# STERLING RECYCLING FACILITY

## SITE DEVELOPMENT PLAN

NES: ADDED.  
PCD File # PPR2341

1
1 OF 4

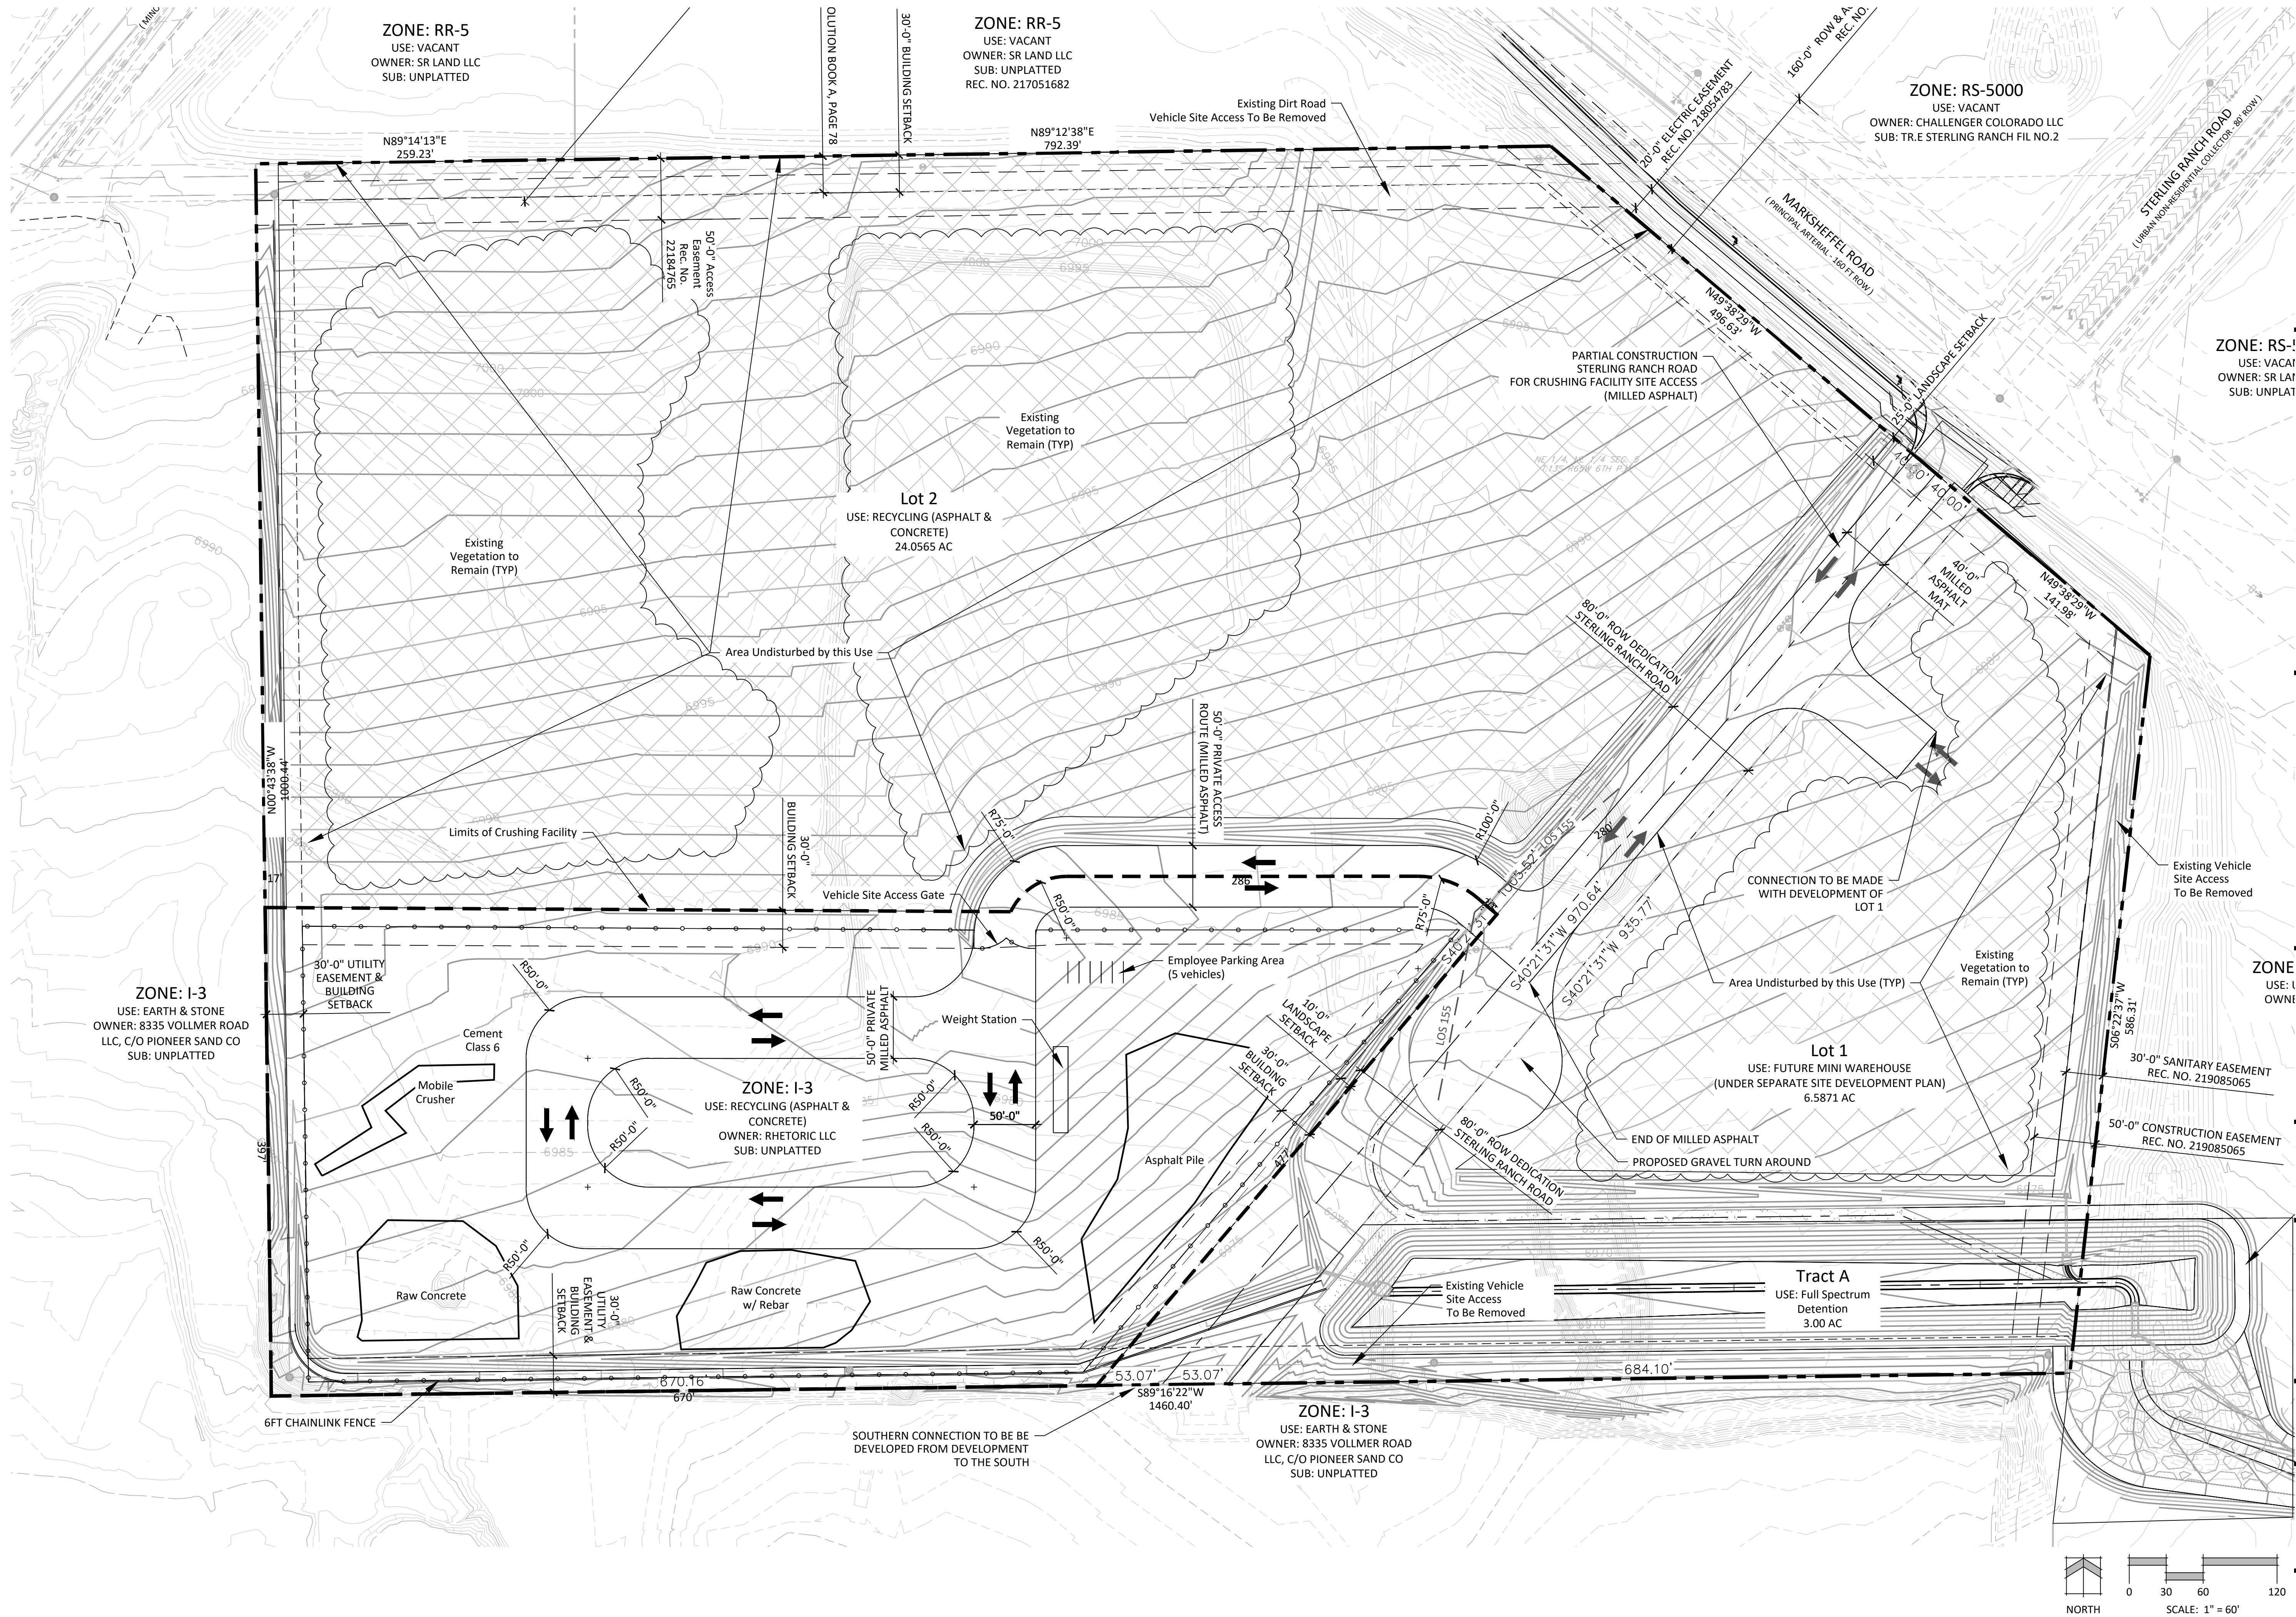
NES: PROVIDED ON THE COVER SHEET.  
Please add the following:  
Property tax schedule number  
Property address  
Lot coverage calculation  
Open space, landscaping, impermeable surface percentage  
Parking computations (whats required and what is being provided)

SITE DEVELOPMENT PLAN

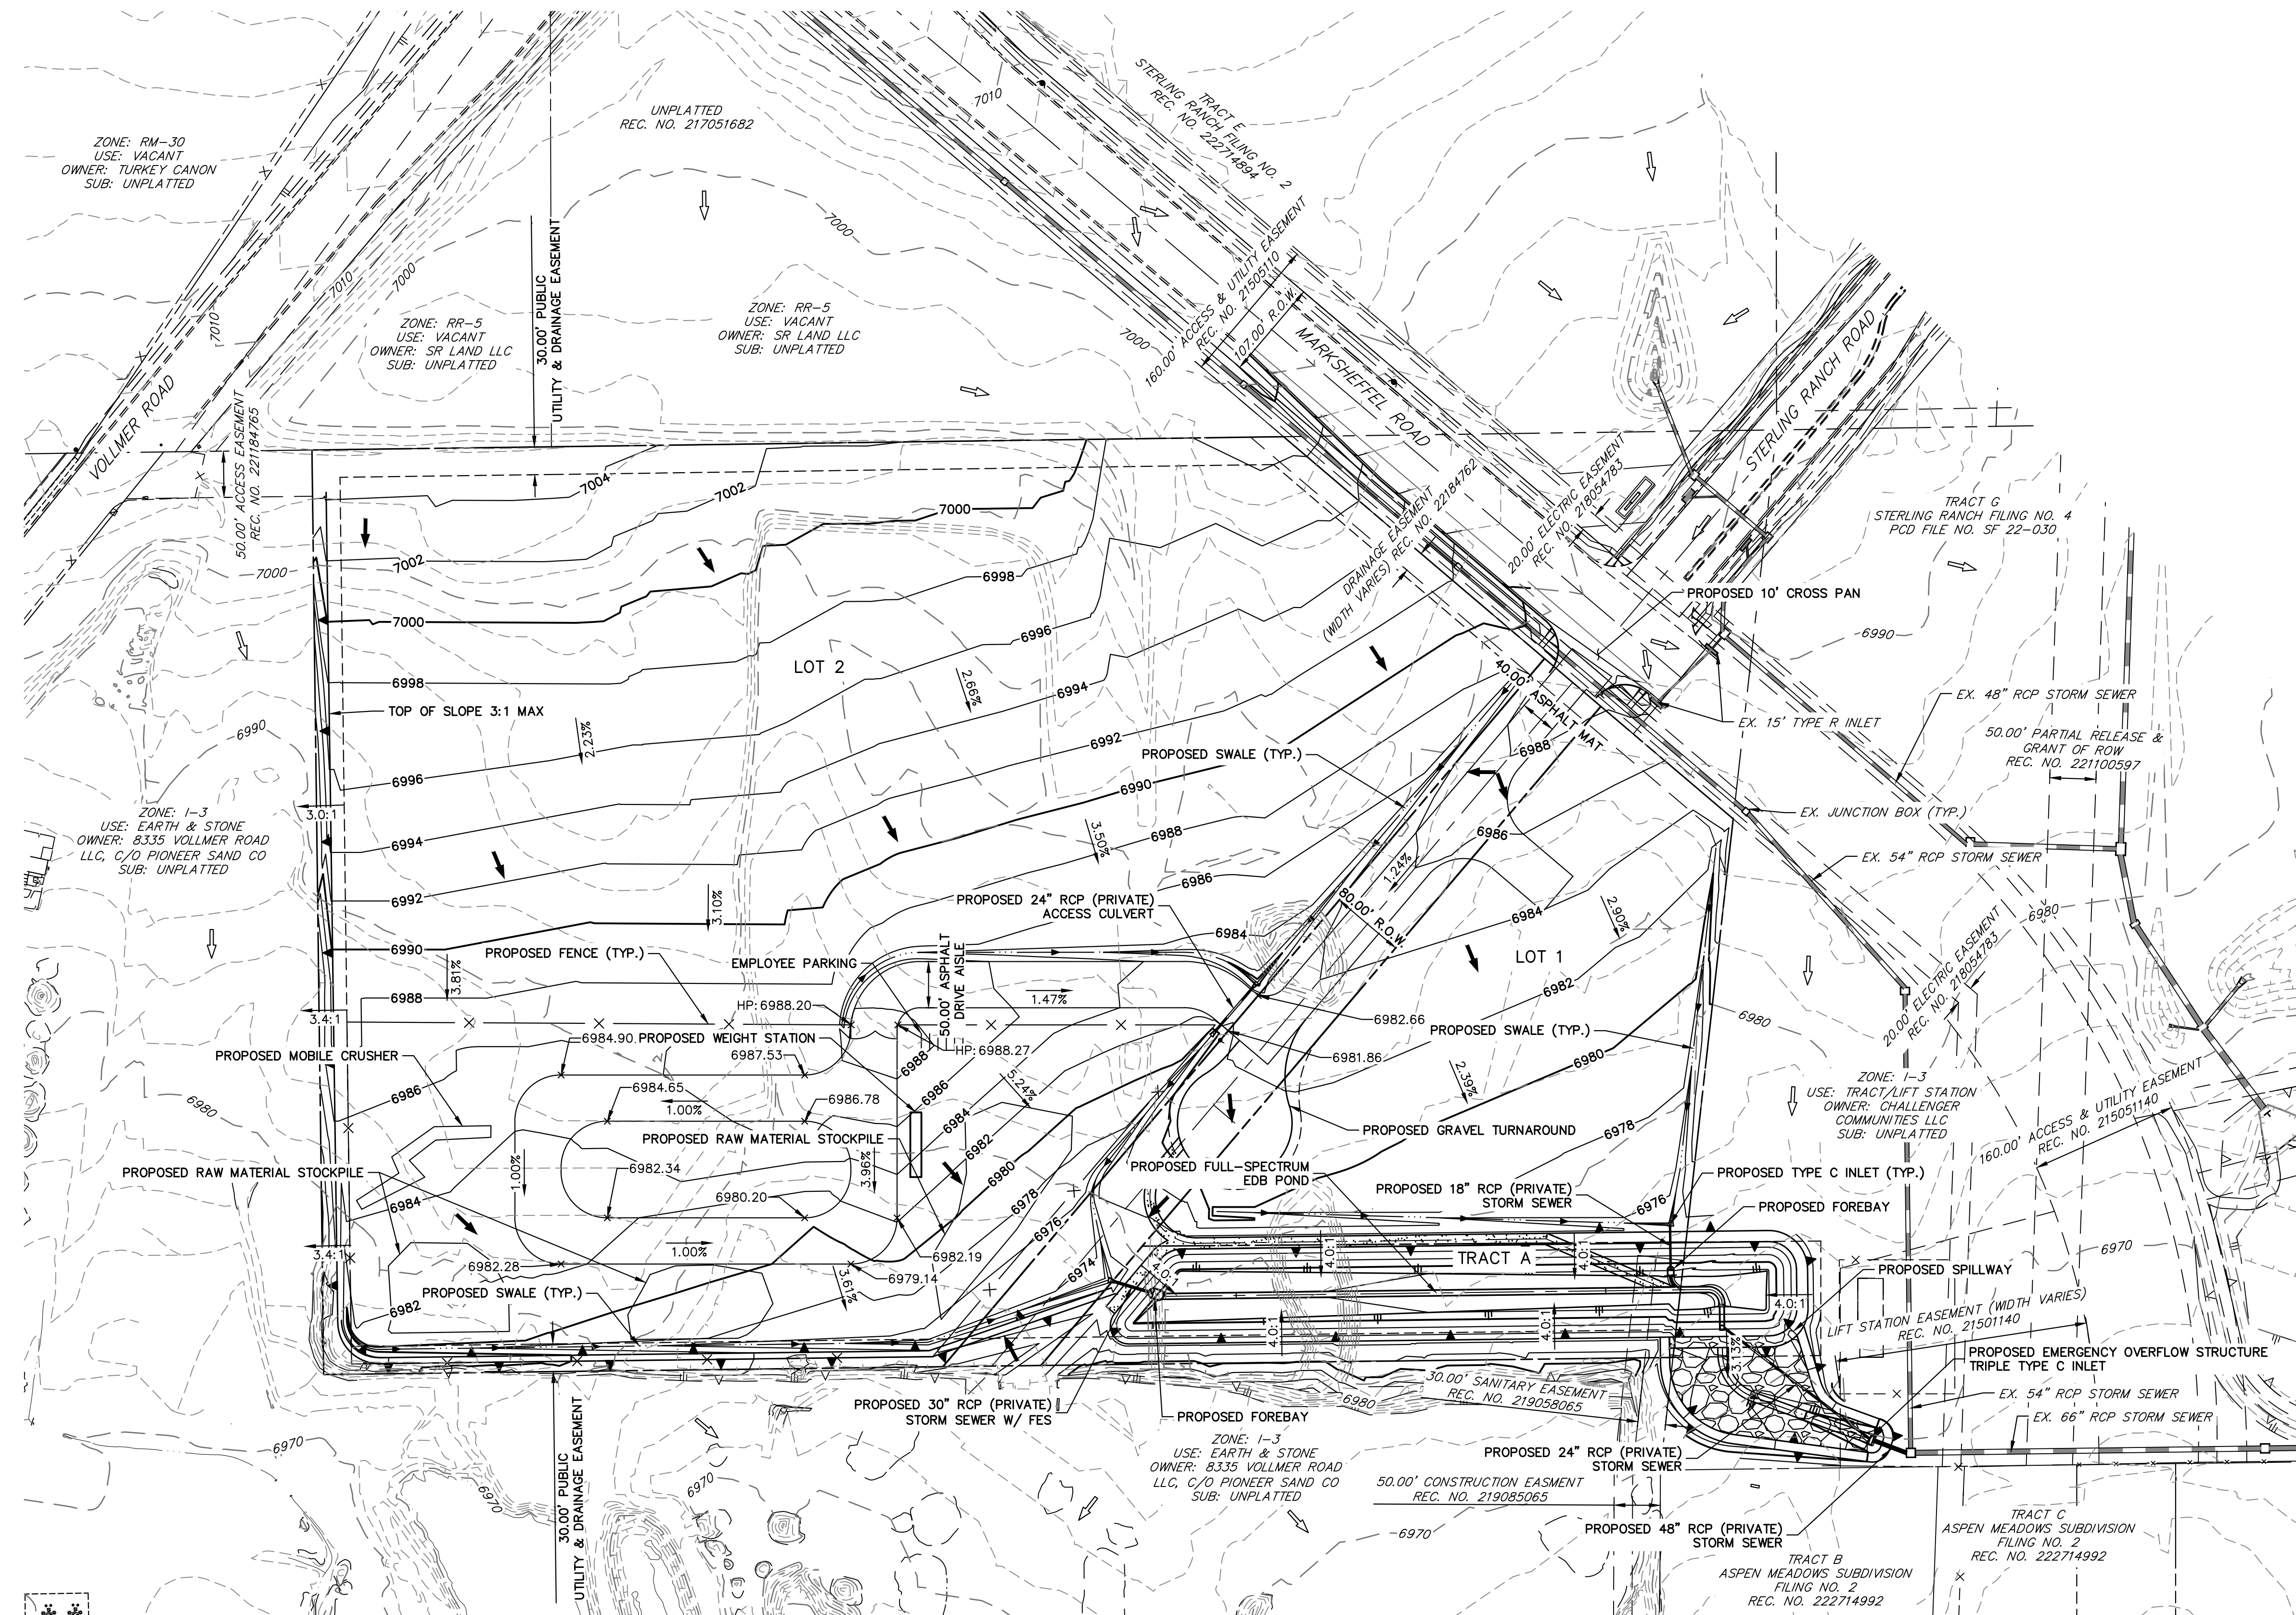
NES: REVISED.  
Asphalt milling's does not match CD or FAE Sterling Ranch Rd is full Asphalt

NES: ADDED.  
Label Road name and classification and ROW

NES: REVISED.  
Entrance min 25ft max 40ft Please correct entrance

NES: ADDED.  
Add missing parcel # for adjacent properties

See note on Plat SF2325

Show access and maintenance easement around pond  
NES: ADDED.

Include only the acreage on the lot 1.85ac  
NES: REVISED TO MATCH PLAT.

Show and call out detention easement with Rec # and indicate size  
NES: EVERYTHING HAS BEEN REVISED BESIDES REC. NO SINCE IT HAS NOT BEEN RECORDED.

NES: REVISED TO MATCH PLAT AND EXCLUDE TRACT A.
